CITY OF ALBUQUERQUE

November 4, 2016

**RE: Rio Vista Apts. Grounds Renovation.
770 Juan Tabo NE
Grading and Drainage Plan
Engineers Stamp Date 8/31/16 (K22D011)**

C101

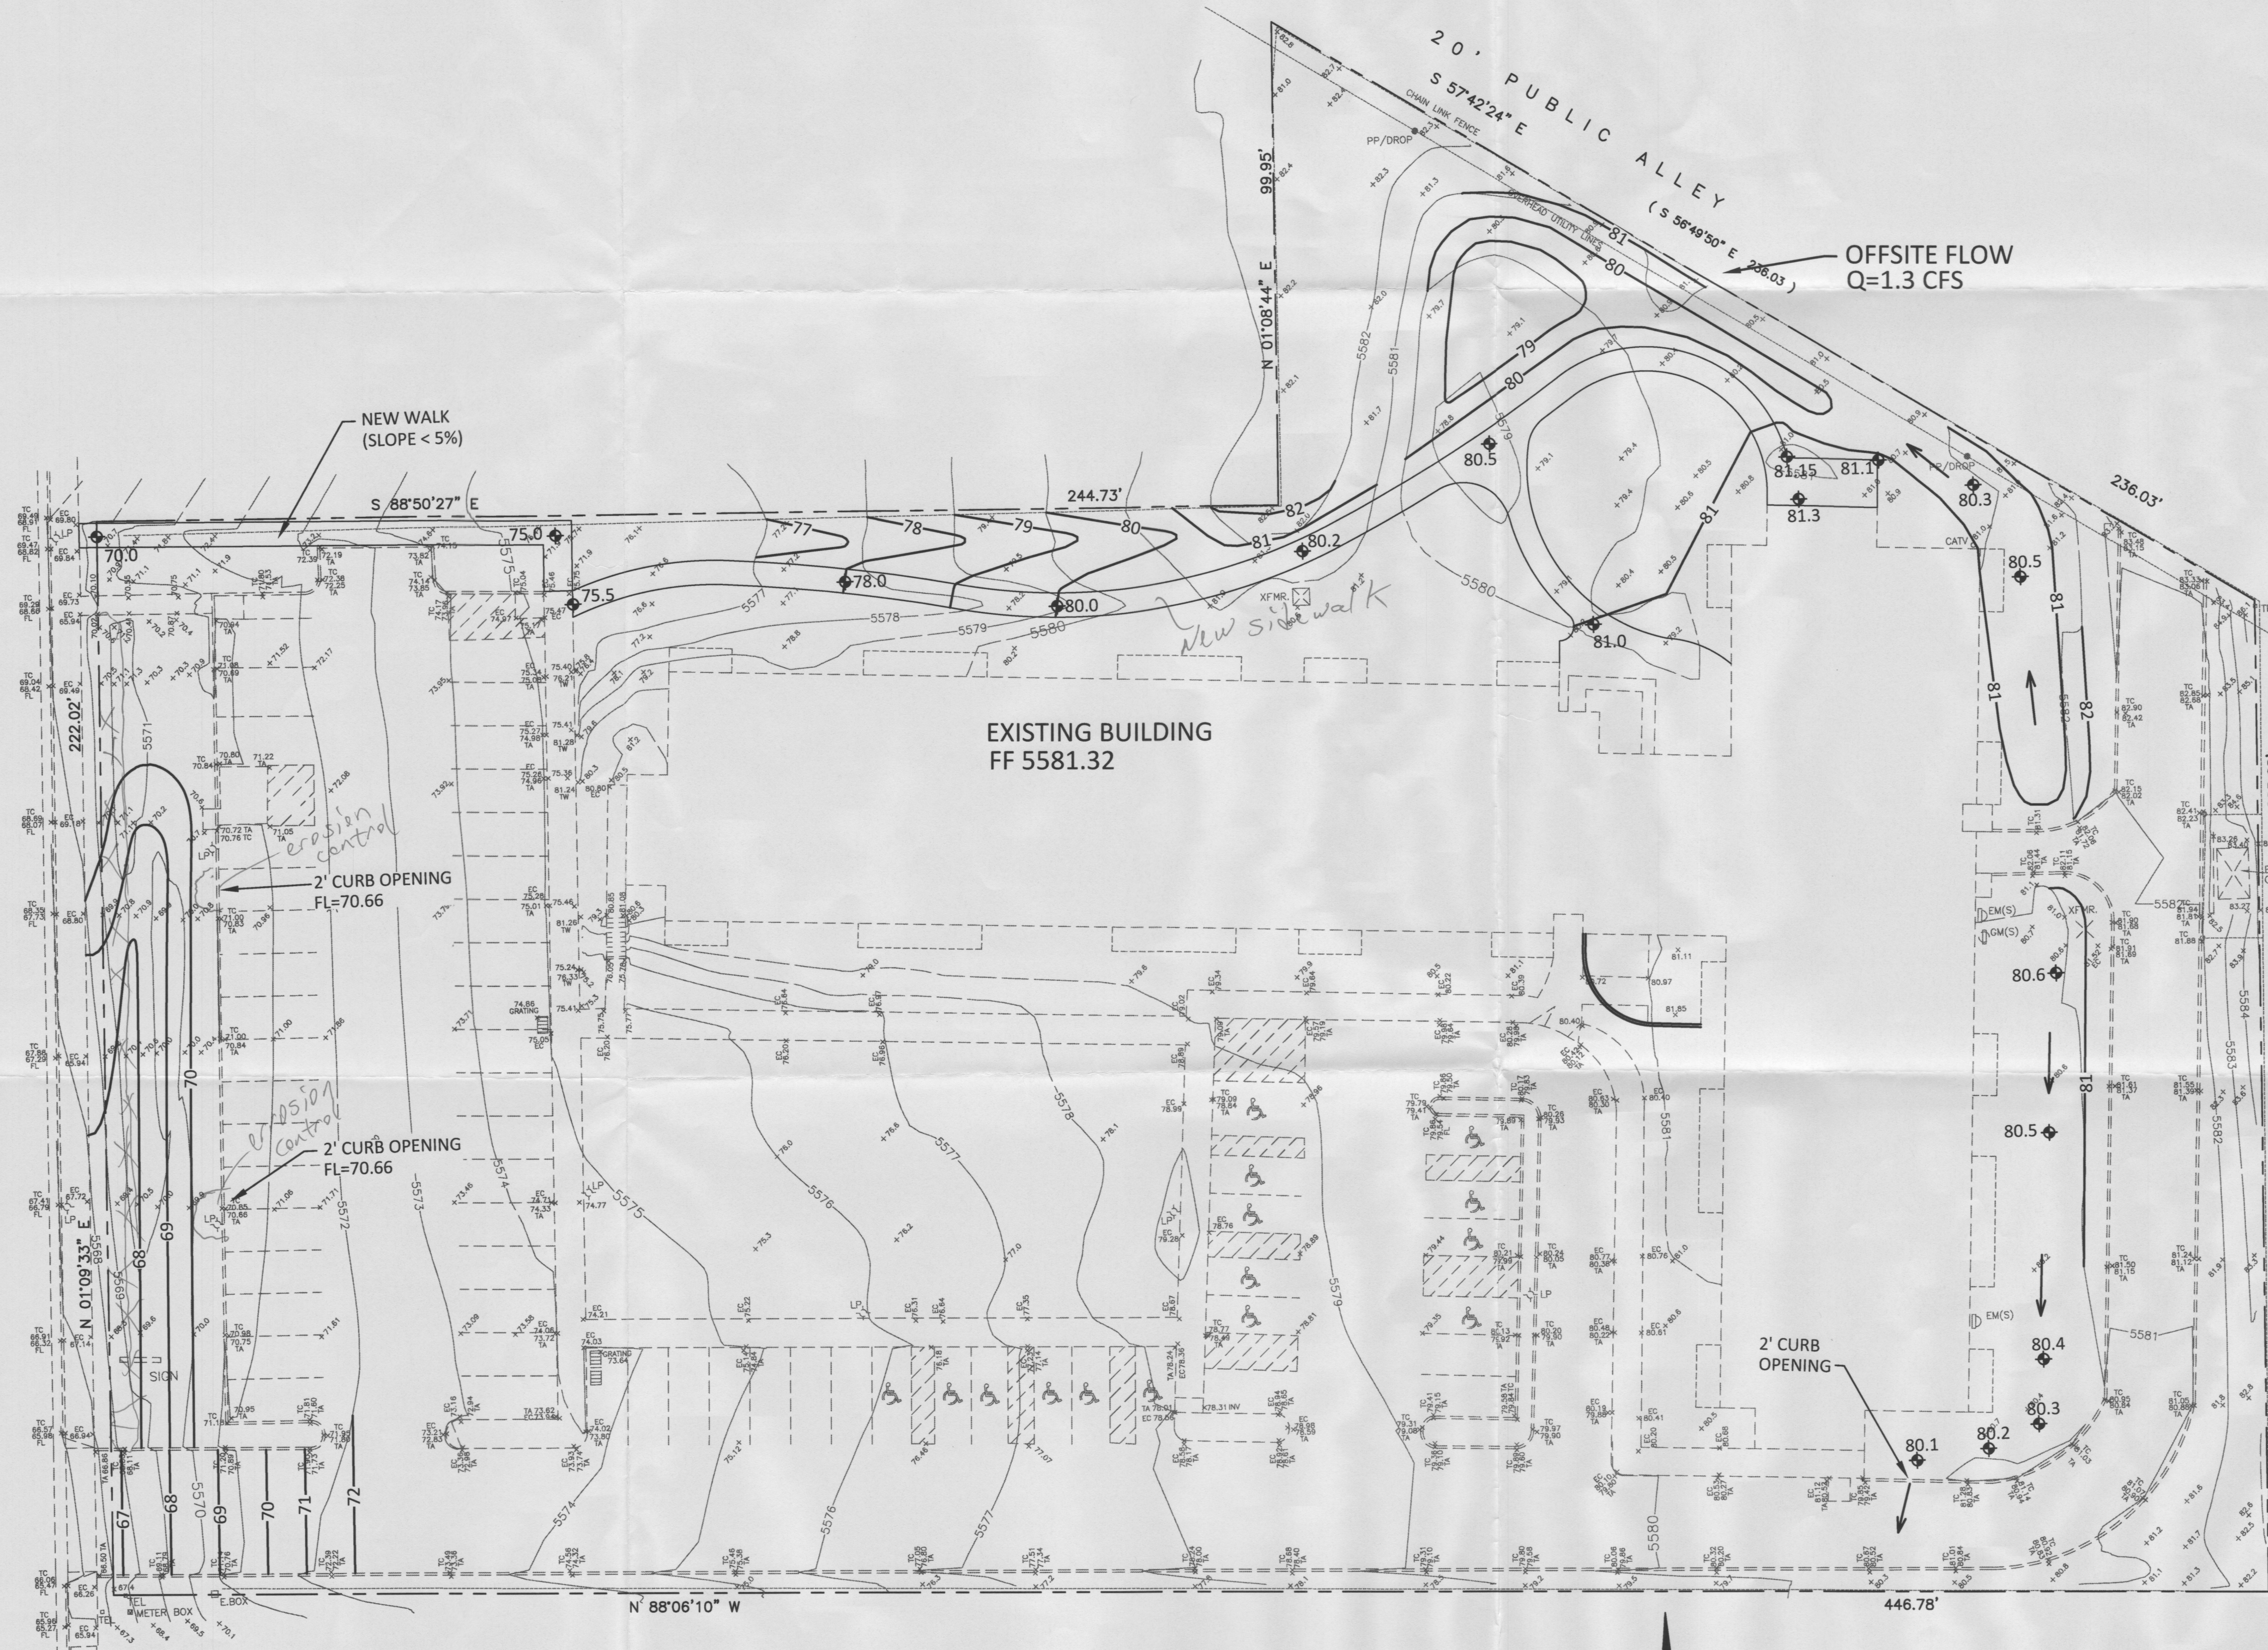
Based upon the information provided in your submittal received 10/21/16, this plan is approved for a grading permit. As mentioned, provide erosion protection for the sloped landscaped area to the west, along with a gravel swale at the bottom for a sedimentation catch.
